**SECTION 4.55(1A) MODIFICATION APPLICATION (MOD 4) MP09_0165
SYDNEY SUPERYACHT MARINA, ROZELLE BAY**

This application has been prepared by Ethos Urban on behalf of Sydney Superyacht Holdings Pty Ltd as trustee for the Sydney Superyacht Trust, pursuant to section 4.55(1A) of the *Environmental Planning and Assessment Act 1979* (EP&A Act) to modify Project Approval (09-0165) for the Sydney Superyacht Marina, Rozelle Bay (the site).

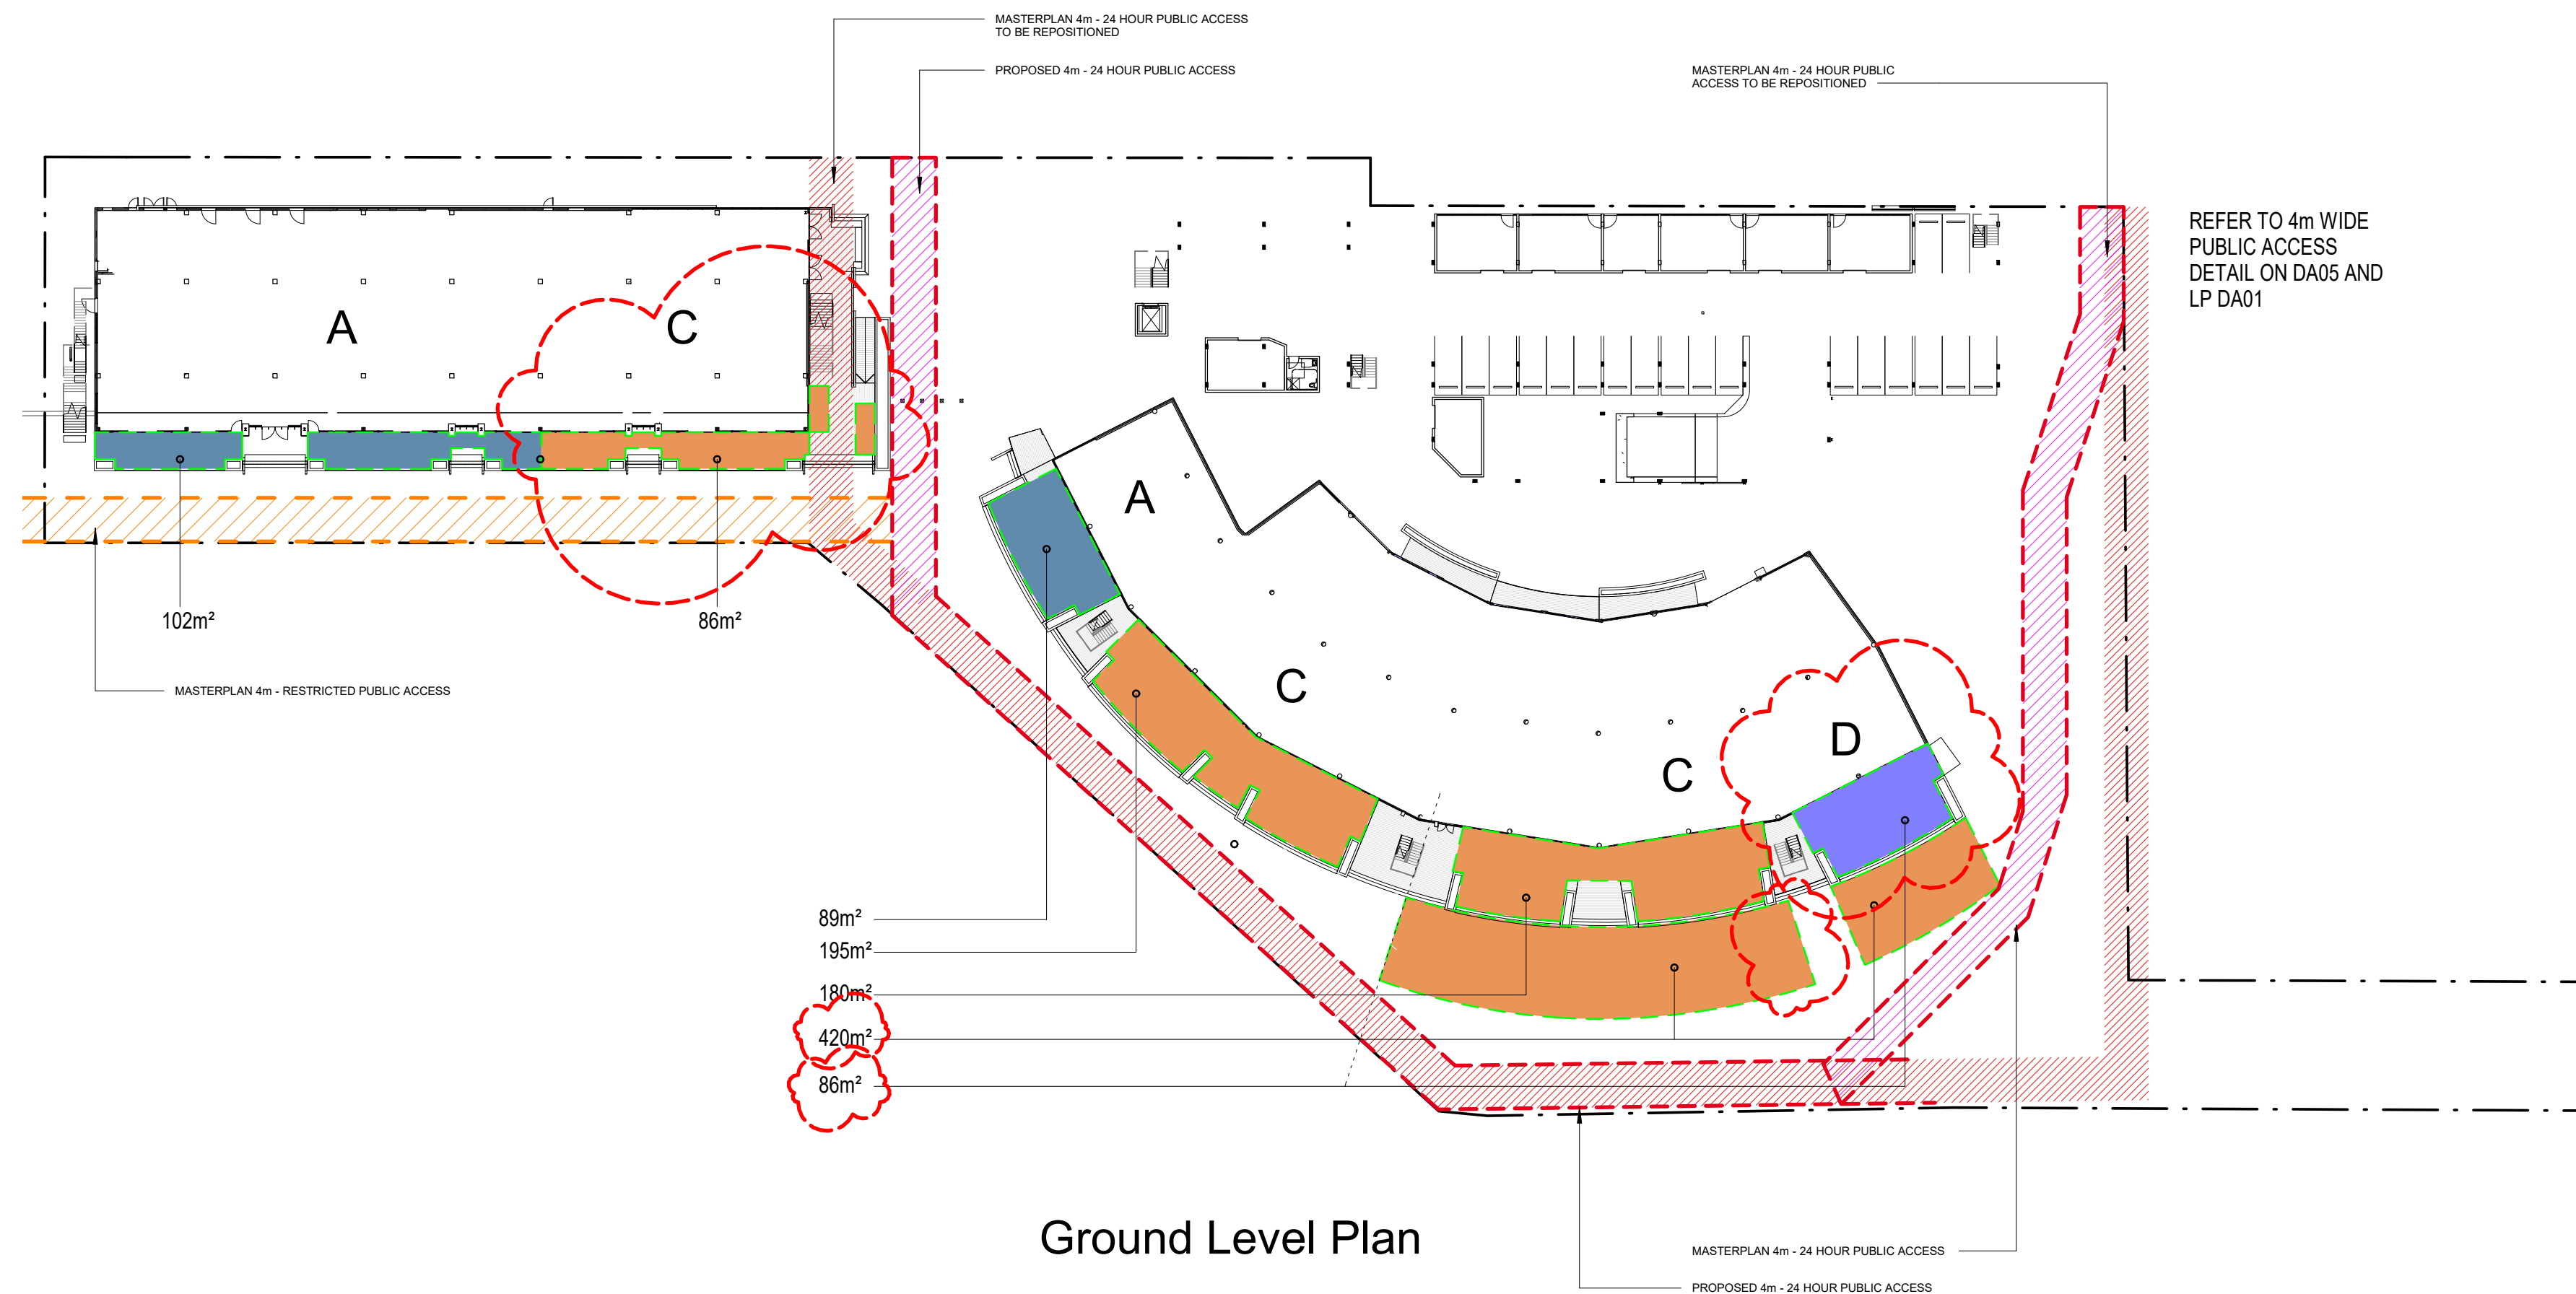
The proposed modifications, illustrated in **Figure 2** below, relate to swapping the currently approved provedore use at the eastern end of the western building with the ancillary (café) use at the eastern end of the eastern building. There is no resulting change in the currently approved GFA, likewise the same ratio of land uses is maintained. The associated approved outdoor seating is also proposed to be relocated, ensuring the same area of seating remains associated with the land use.

Drawing No.	Rev.	Name of Plan	Date
DA13	F G	Tenancy Diagram	16.06.2016 09.05.2018
DA19	G H	Outdoor Seating Diagram	16.06.2016 09.05.2018
DA30	A	West Building- Ground Floor	07.08.2015
DA31	A	West Building- First Floor/Roof	07.08.2015
DA32	A	West Building- Elevation	07.08.2015
DA33	A	West Building- Elevations/ Section	07.08.2015
DA34	A	East Building- Ground Floor	07.08.2015
DA35	A	East Building- First Floor	07.08.2015
DA36	C	East Building- Second Floor	07.08.2015
DA37	B	East Building- Roof Plan	27.04.2016
DA38	B	East Building- Elevations	27.04.2016
DA39	B	East Building- Elevations	27.04.2016
DA40	B	East Building- Section	27.04.2016
DA41	A	East Building- Section	07.08.2015
DA42	B	Carpark- Ground Floor	07.08.2015
DA43	B	Carpark- First/Second Floors	22.06.2016
DA44	A	Carpark- Elevations	07.08.2015
DA45	A	Carpark- Elevations/Section	
Landscape plans			
LP DA01	F	Landscape Masterplan	20.07.2016
LP DA02	D	Landscape Plan Levels 1 & 2ms Photomontage 2/2	20.07.2016

The outdoor seating areas are to be generally consistent with those areas allocated to each tenancy as detailed on approved plan DA19 ~~Rev. G~~ **Rev. H**, as read in conjunction with approved Plans LP DA 01 Rev. F and LP DA 02 Rev D. The southern extent of the outdoor seating associated with the ancillary use of the ground floor level of the Eastern Building is to be defined by the landscape planters as illustrated on approved plan LP DA 01 Rev. F.
